**KIRKLEES METROPOLITAN COUNCIL
INVESTMENT & REGENERATION SERVICE**

DELEGATED DECISION TO DETERMINE PLANNING APPLICATIONS

Reference No:	2025/62/90203/E
Site Address:	73, Burnley's Mill Road, Gomersal, Cleckheaton, BD19 4PH
Description:	Erection of single storey rear extension
Recommending Officer:	Faiza Bano

HOUSEHOLDER DELEGATED REPORT

Drawing No. (0112) - P500 Revision A

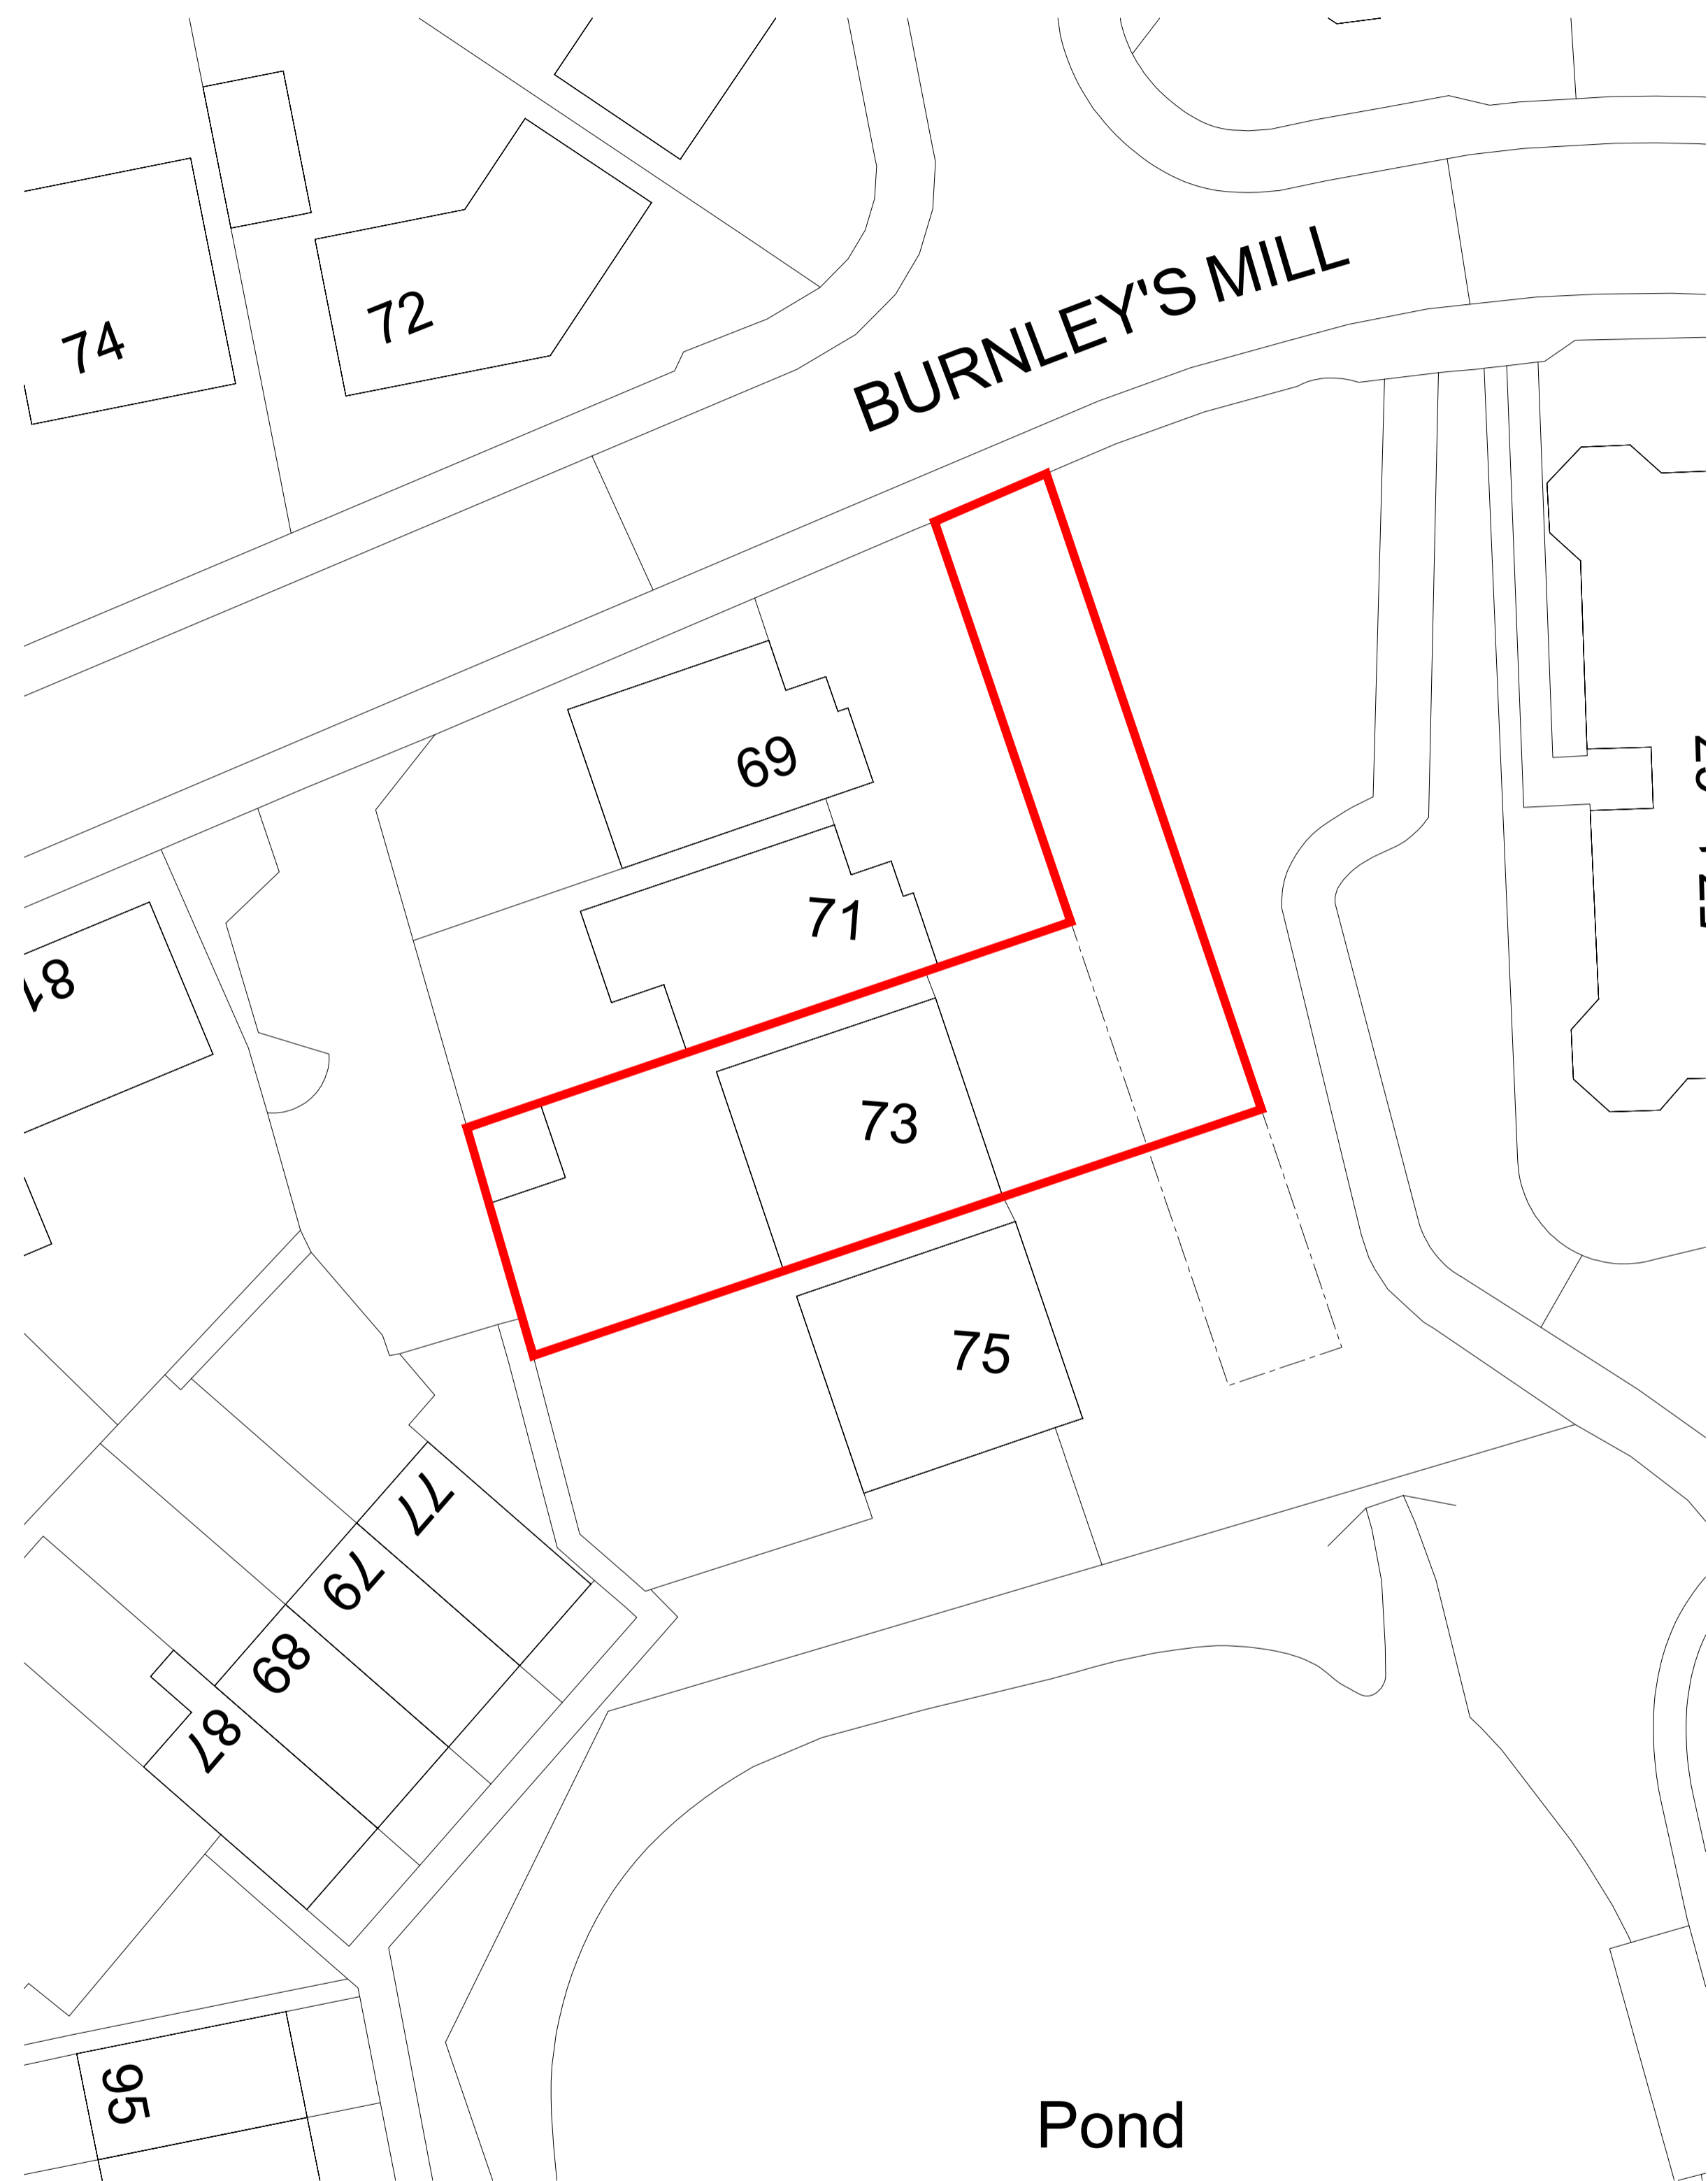
Rear Extensions Should:	<u>Yes - COMPLY</u>	<u>No - JUSTIFY</u>
respect the original house and garden in terms of its size and scale	Yes – the extension does not cover more than half of the total area around the original house.	
use appropriate materials which match or are similar in appearance to the original house; and	Yes – to match existing	
not have an adverse impact by way of overshadowing or loss of outlook of neighbouring properties.	Due to the single-storey nature of the applicant site, the proposed extension will not overshadow neighbouring properties. Due to the modest scale of the proposed extension, there will be no impact on the loss of outlook of neighbouring properties.
